From: Philip Woolger [REDACTED]
Sent: 27 October 2020 12:34
To: Kathryn Welch <Kathryn.Welch@arun.gov.uk>
Subject: RE: 8 Fernhurst gardens.

From: "Kathryn Welch" <Kathryn.Welch@arun.gov.uk>
To: "Philip Woolger" [REDACTED]
Sent: Tuesday, 27 Oct, 20 At 10:51
Subject: RE: 8 Fernhurst gardens.

26'~8.m

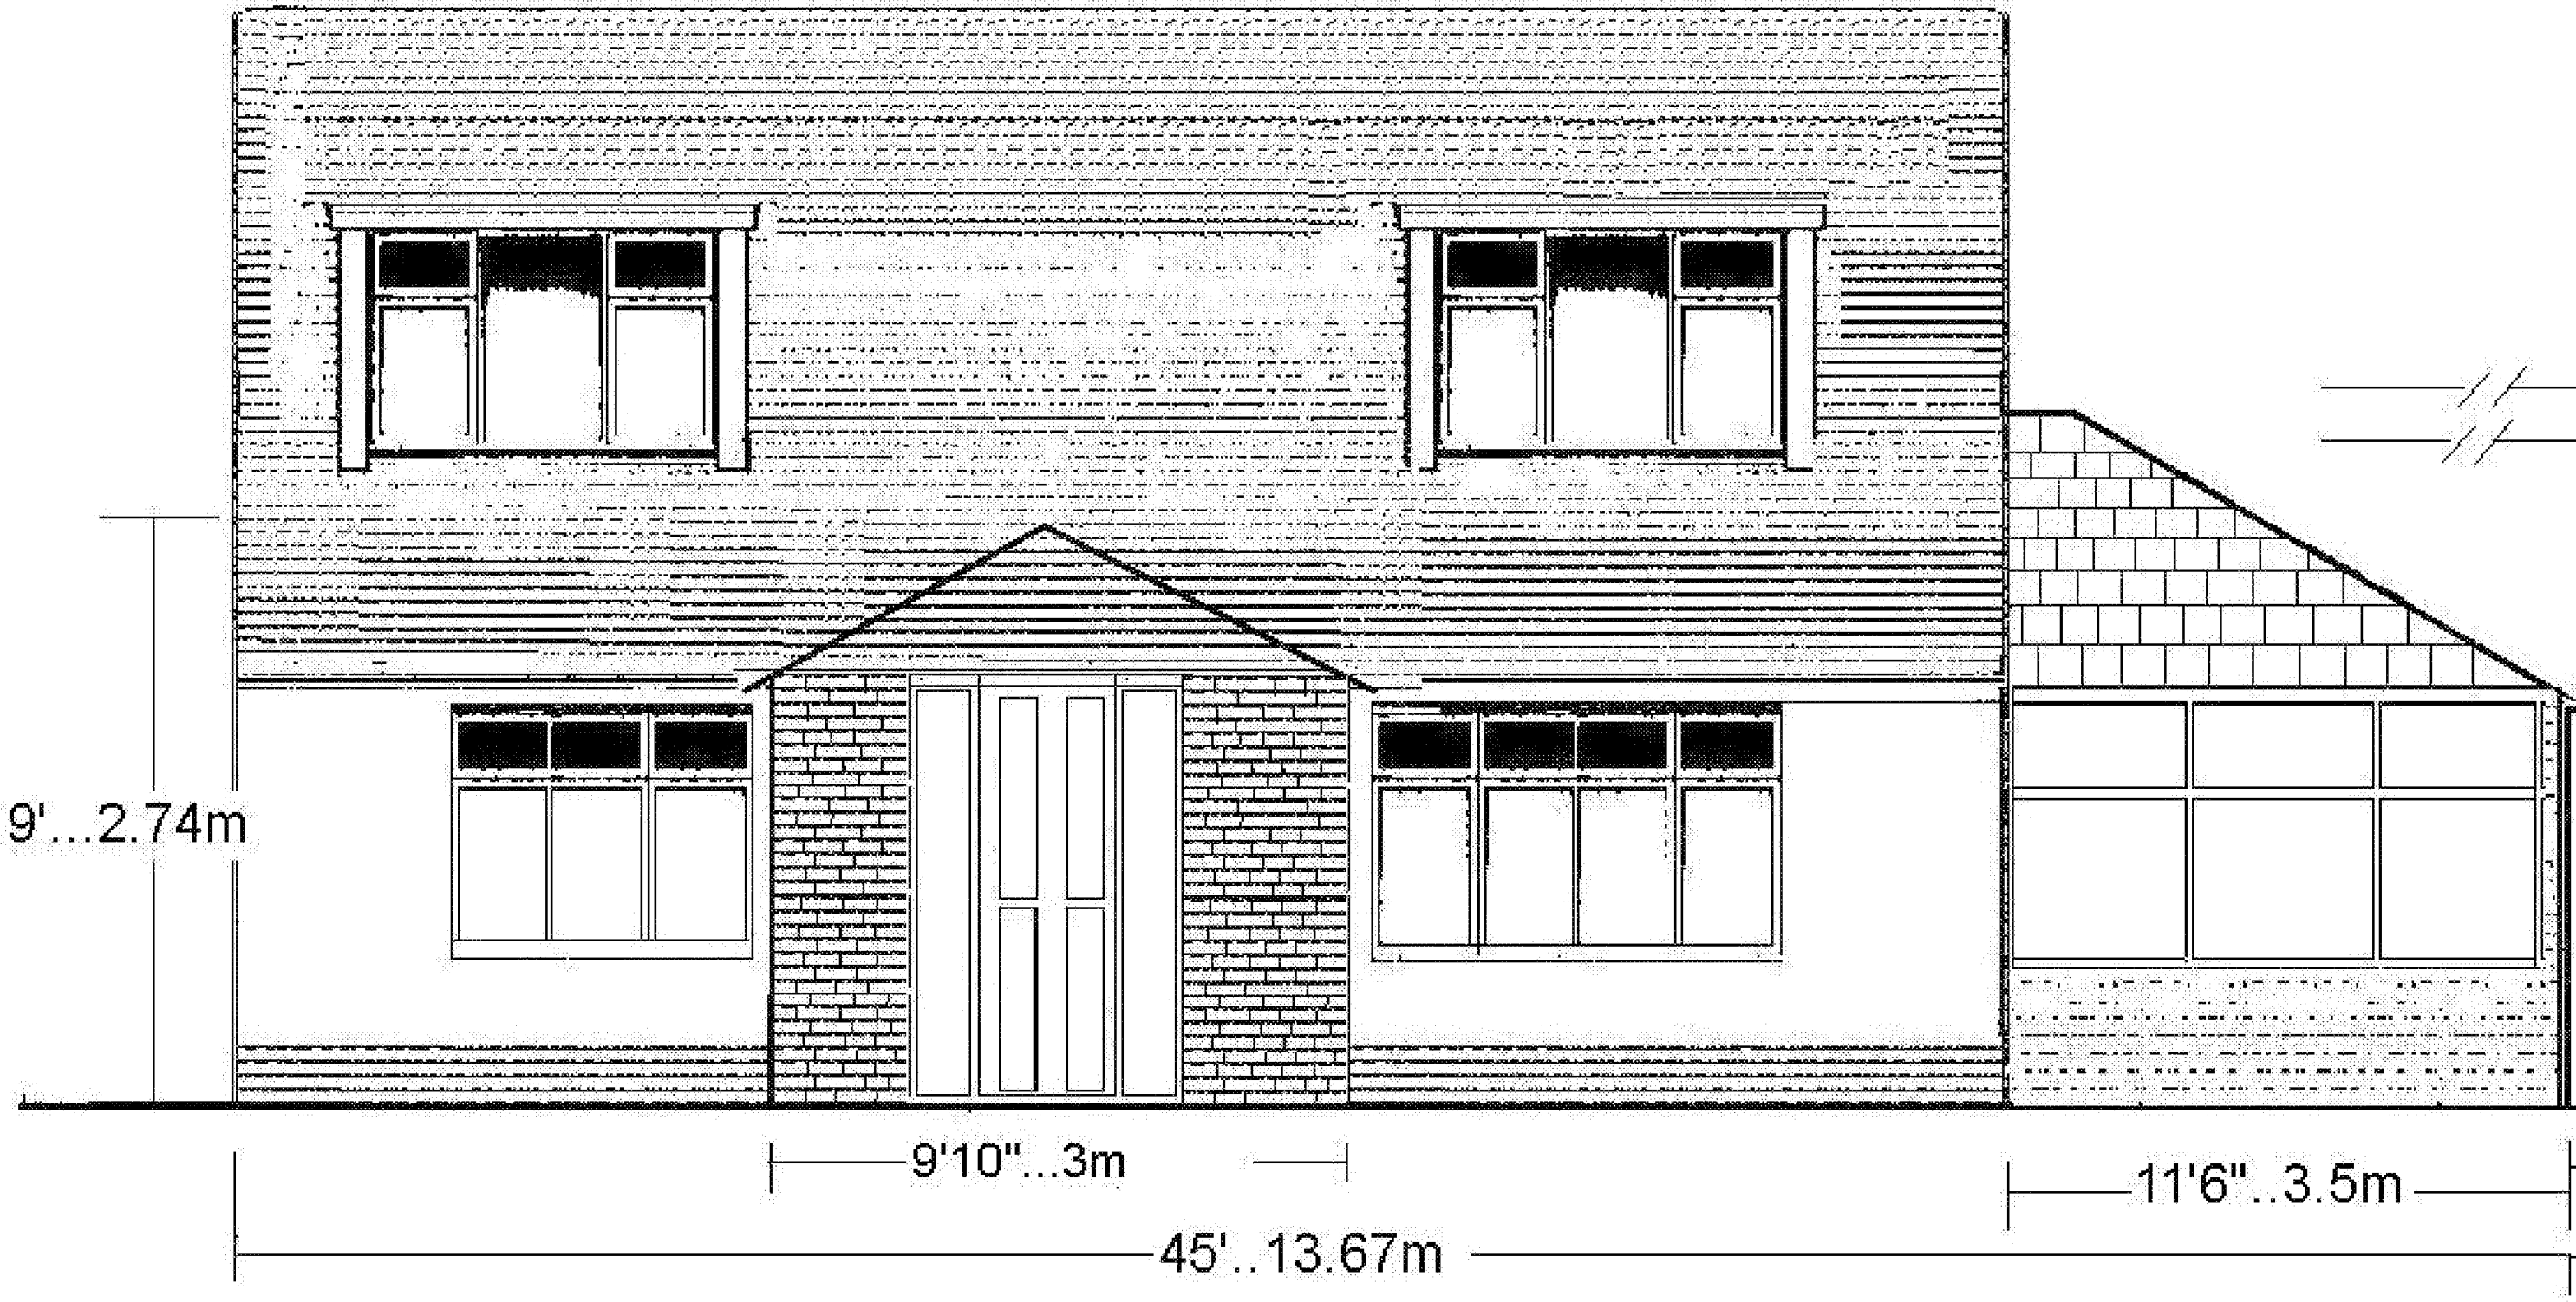
- The porch is slightly too large, to be covered by PD rights the maximum allowance is 3m² and your proposal currently measures at 3.84m² can you adjust this on plans 010 and 003.
- Can I have confirmation of the height to the eaves for the extension, either via email or included within a plan,
- Can you confirm that the extensions will be built of materials to match the existing property. You've noted a concrete slate tile on the roof of the extension; do you already have these on the existing house or can you amend to something similar to the existing,
- Can you confirm the proposed hardstanding for 2-3 cars will be built of either porous materials or will drain off to water permeable area within the site, again just a written confirmation will suffice.

porch 3m x 1m ...2.2m to eaves.....Antique red Marley plain tile 265 x 165mm as per existing building.....and Block paved driveway (we were planning on this)just missed it off. We understand about the drain off on solid concrete.

Attached drawing 003...and 010...adjusted .
